April 26, 2018

Subject:
DRB Project #1010675
PHS Ambulatory Care Facility
Coors Boulevard NW
Albuquerque, New Mexico 87120

Below are responses to the DRB Transportation comments received on 4/18/2018.

SDP-1.1

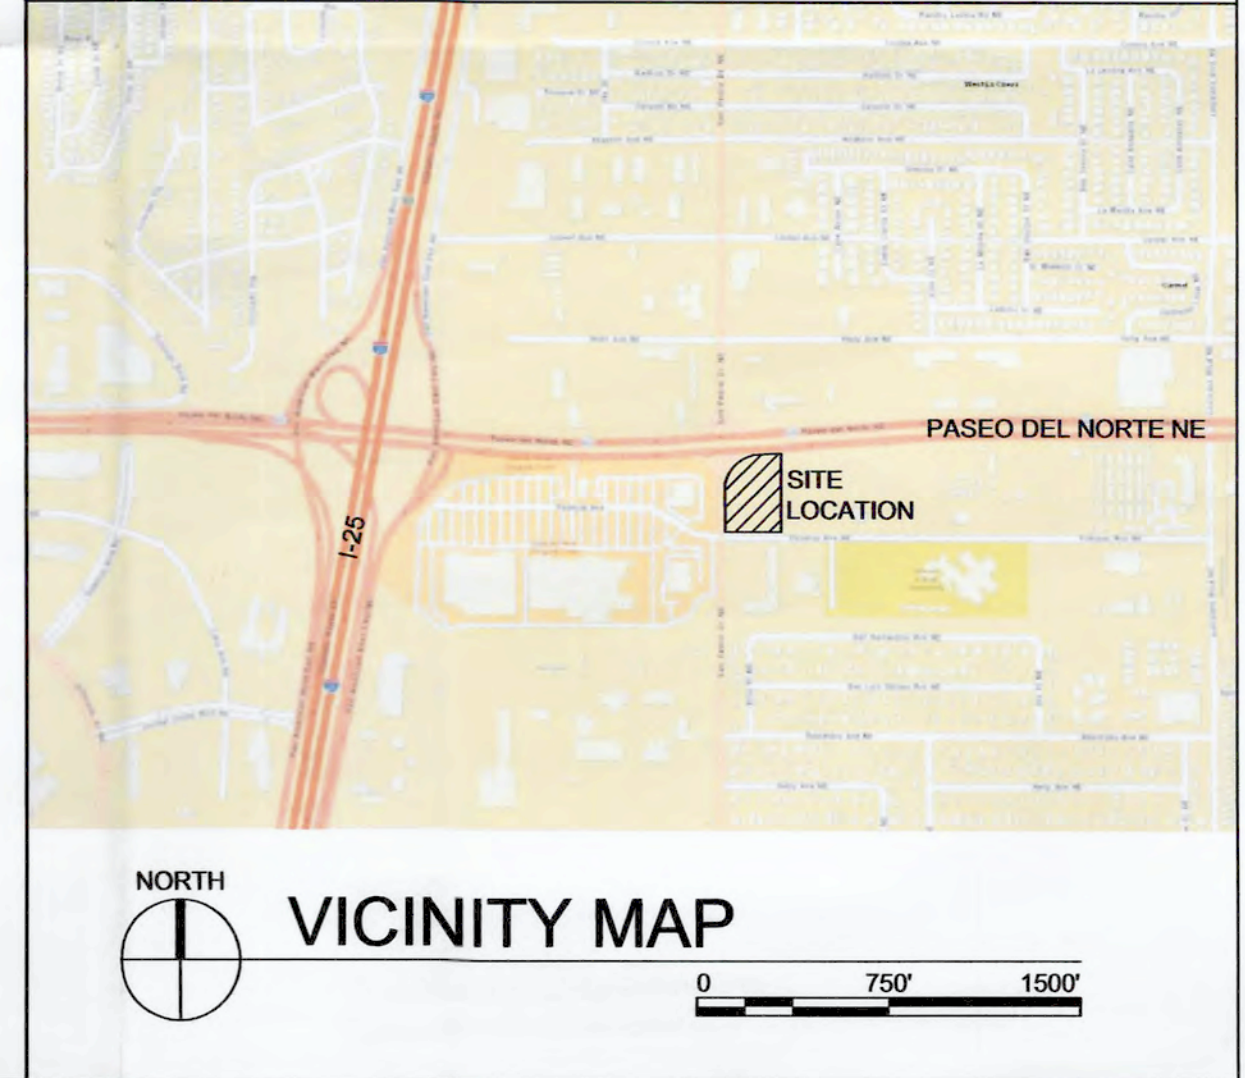
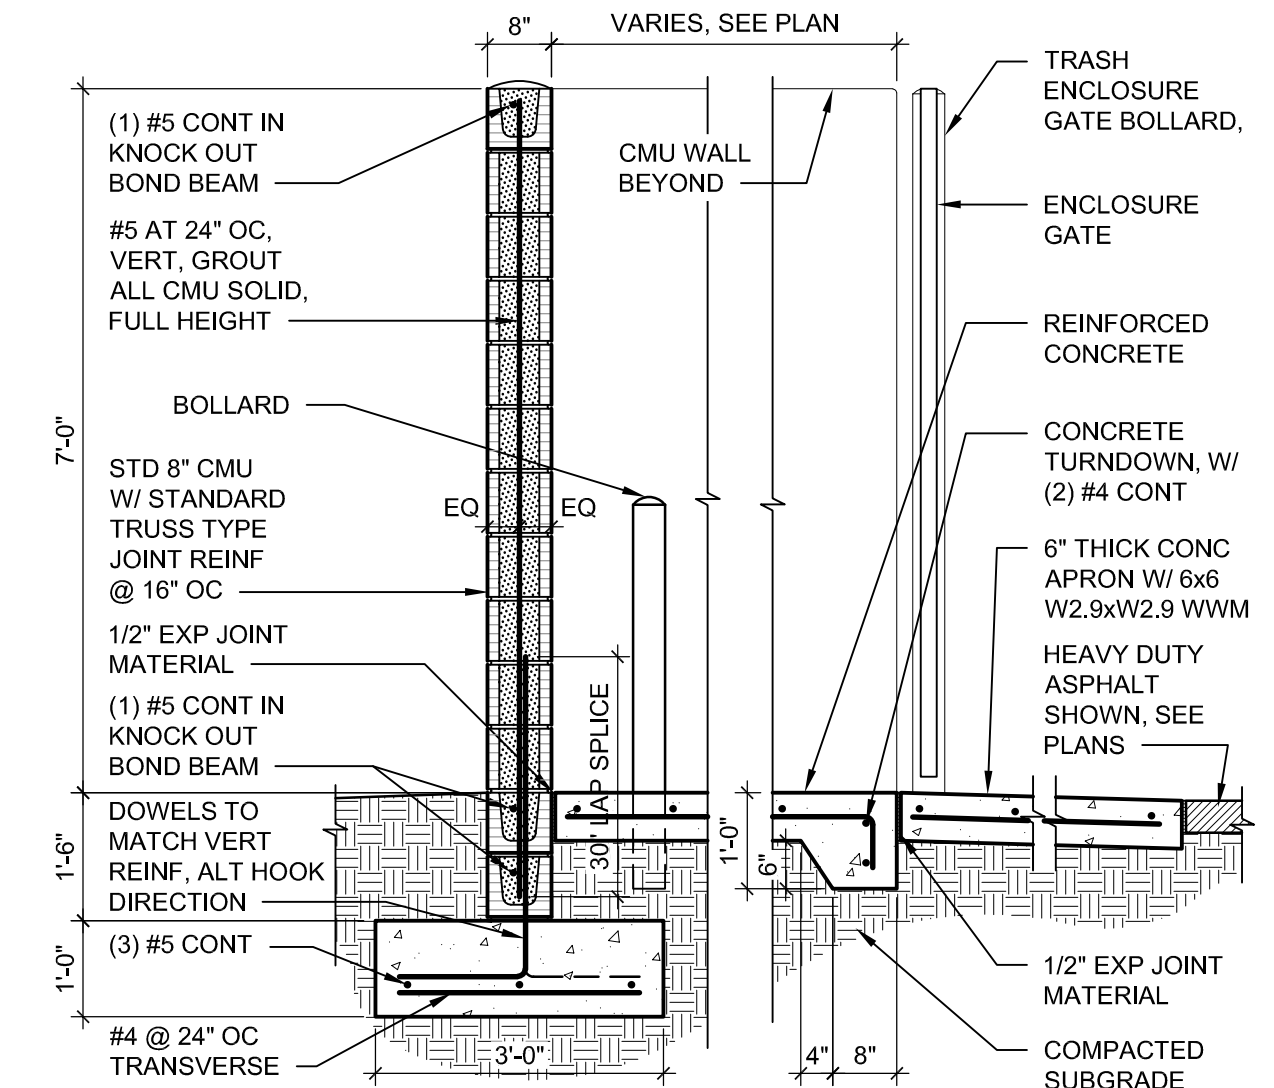
1. Motorcycle parking spaces shall be designated by its own conspicuously posted upright sign, either free-standing or wall mounted per the zoning code. List the width and length for motorcycle parking spaces.

2. Show the clear sight triangle and add the following note to the plan. "Landscaping and signage will not interfere with clear sight requirements. Therefore, signs, walls, trees, and shrubbery between 3 and 8 feet tall (as measured from the gutter pan) will not be acceptable in the clear sight triangle."

3. Please add a note on the plan stating "All improvements located in the right-of-way will be included on a Public Work Order."

4. Call out what improvements will be built under the public work order.

Response: Motorcycle parking signage and typical dimensions have been included on the revised site plan.

Response: The clear sight triangles have been shown on the site plan with the required note.

Response: The required note has been added to the general notes on the site plan.

Response: The improvements under the public work order have been called out on the site plan.
